From: Hannah Riddle on behalf of Planning.Responses
Sent: 09 March 2022 16:13
To: Planning Scanning
Subject: FW: P/178/21/OUT Pagham Road

Hello Simon, thanks for this. Ultimately whether the access is within the 30mph or the 60mph makes no difference in this instance as the design of the access and associated visibility splays are based on the recorded speed of traffic rather than the posted speed limit. The applicant's approach to the determining speeds is set out within the submitted transport assessment and summarised further within points 3 and 4 of the WSCC consultation response dated 27th January 2022.

Figure 5: Site Access Arrangement

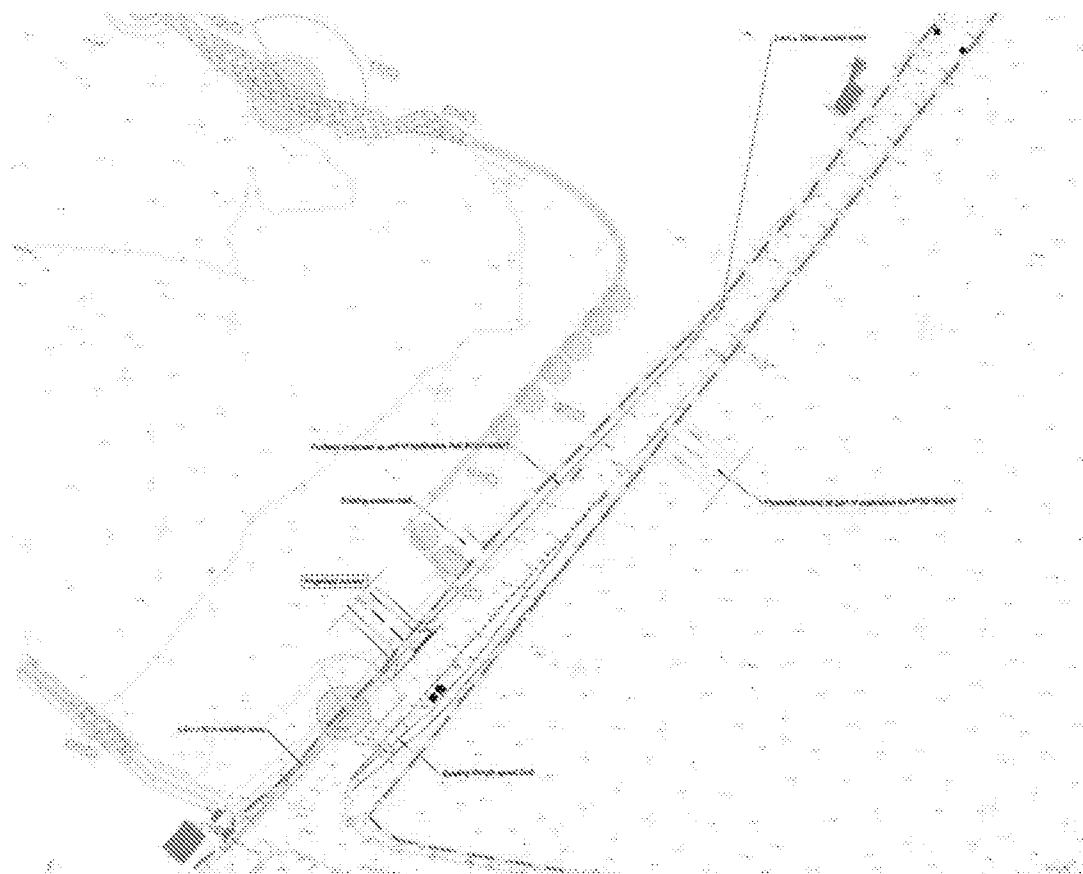
I have had a resident comment stating: *"The comment from WSCC Highways states that "The site is proposed to be accessed via a new priority junction on Pagham Road. Although the access lies within the 30mph speed limit, this changes to the National Speed limit to the immediate north". However, this is not true The Access lies in the national speed limit area, NOT the 30 mph zone. This is clearly seen from either a) visiting the site or b) looking at the access arrangements drawing as provided in the application. I am concerned that has the WSCC Highways team been aware of this, they may have concluded differently on what the appropriate visibility splays are."*

I have checked Google Streetview and the access is beyond the national speed limit sign.

This refers to your first comments dated 28/01/22 and in your most recent comments you don't mention visibility. Can I just check whether you need to review this or not?

The only matter the applicant was asked to address within the initial WSCC response was to provide copies of the speed survey data as this was missing from the initially submitted TA. This information was subsequently provided and WSCC confirmed that the data, and subsequently the visibility splays, were acceptable. This was confirmed in the consultation response dated the 24th February 2022.

Whilst the location of the 30mph speed limit may have been referred to incorrectly, this has no bearing on the access design and visibility splays in this instance given the use of recorded speeds. WSCC Highways are satisfied that the required level of visibility can be achieved. It should be noted that in practice given the road alignment, significantly greater visibility splays are achievable beyond those required for the recorded speed of traffic.
